Re: The New Warnervale Public School, responses to the SSDA exhibition comments

This letter has been drafted to provide Comment on the response to submissions specifically relating to Bushfire Planning and RFS comment:

CLIENT  
DEPARTMENT OF EDUCATION  
DRAWING TITLE:  
SITE CONTEXT - EXISTING

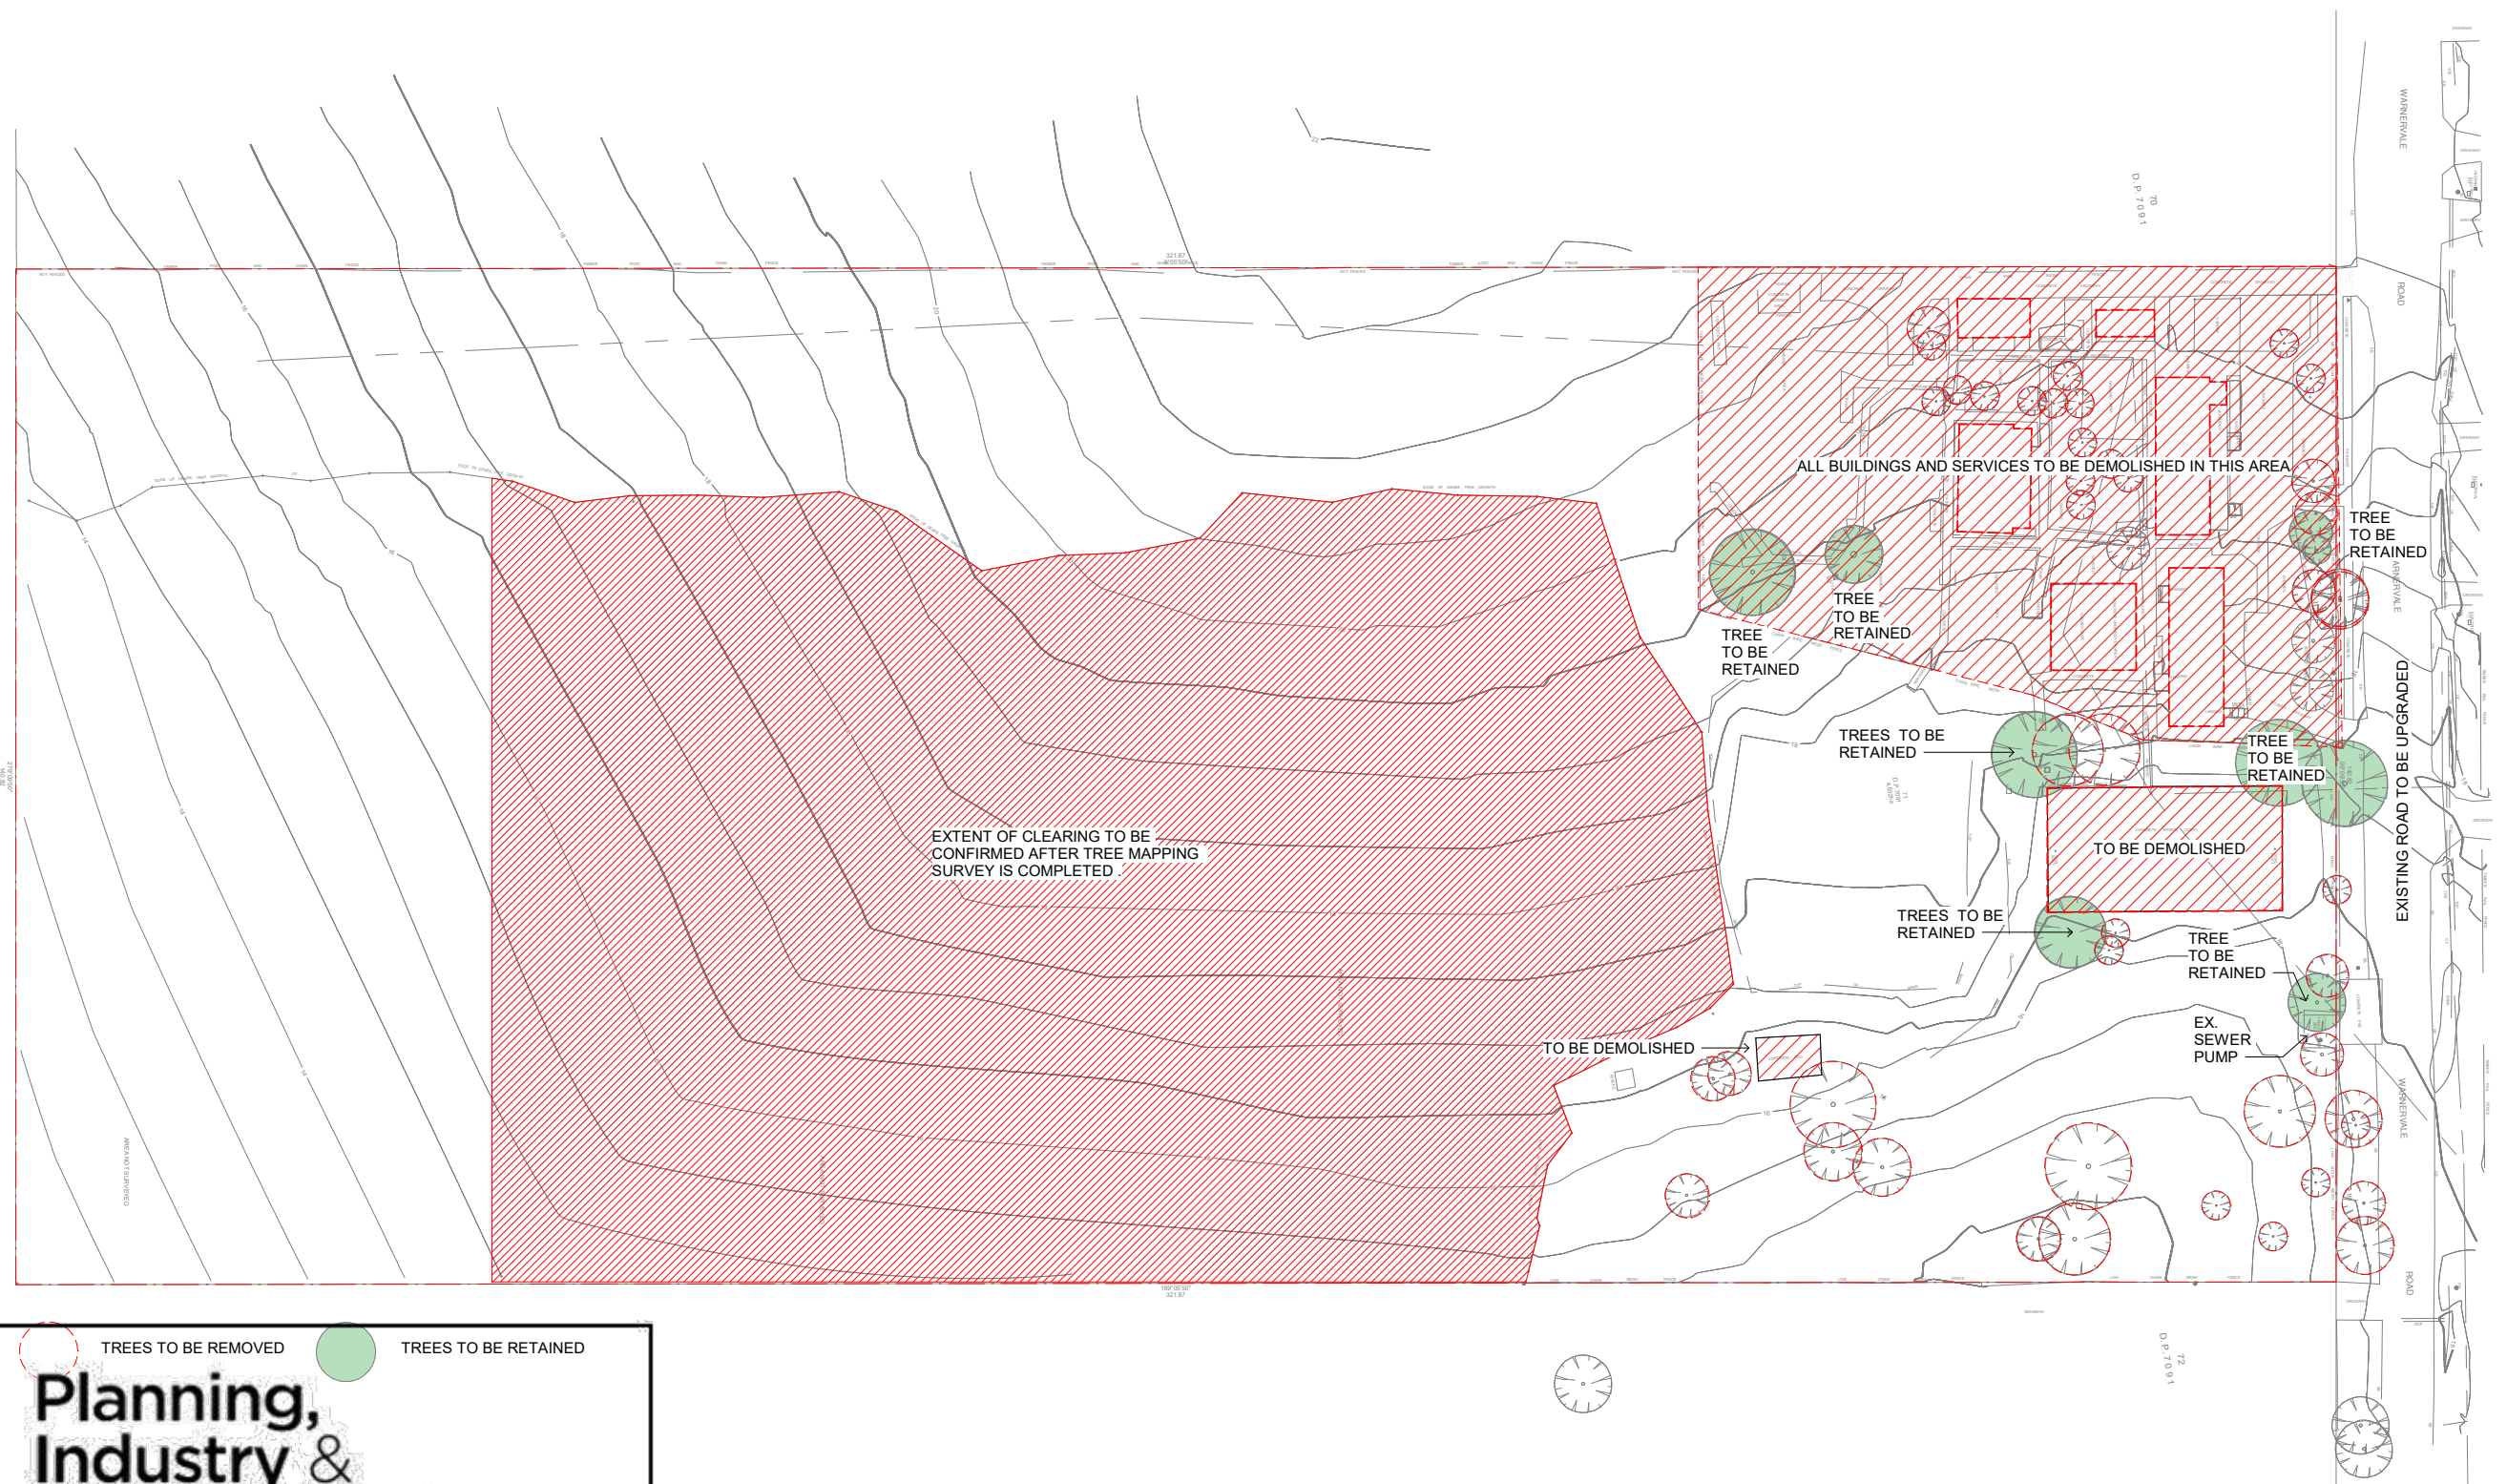
At the commencement of building works in perpetuity, the site boundary setbacks as shown on the Site Context Plan prepared by Billard Leece Partnership, No.AA03-0000, dated 07.08.19., shall be managed as an inner protection (IPA) as outlined within Appendices 2 & 5 of Planning for Bush Fire Protection 2006 and the NSW Rural Fire Service's document Standards for asset protection zones as follows:

- North: to the property boundary;
- East: to the property boundary (11m);
- South: for a minimum distance of 70 metres; and
- West: for a minimum distance of 70 metres. The Administration & Staff Building - Core 21, may have a reduced setback as shown (approximately 52m to the original side boundary).

Due to the rapidly developing landscape and Warnervale Precinct Plan layout surrounding the School site, there is a high likelihood that the bushfire risk will be reduced/removed, such that the APZ are redundant, and the site setbacks could be further developed for school infrastructure purposes. Subsequently additional comment should include: *At the commencement of building works, and in perpetuity (or until the bushfire risk remains)* – or similar wording.
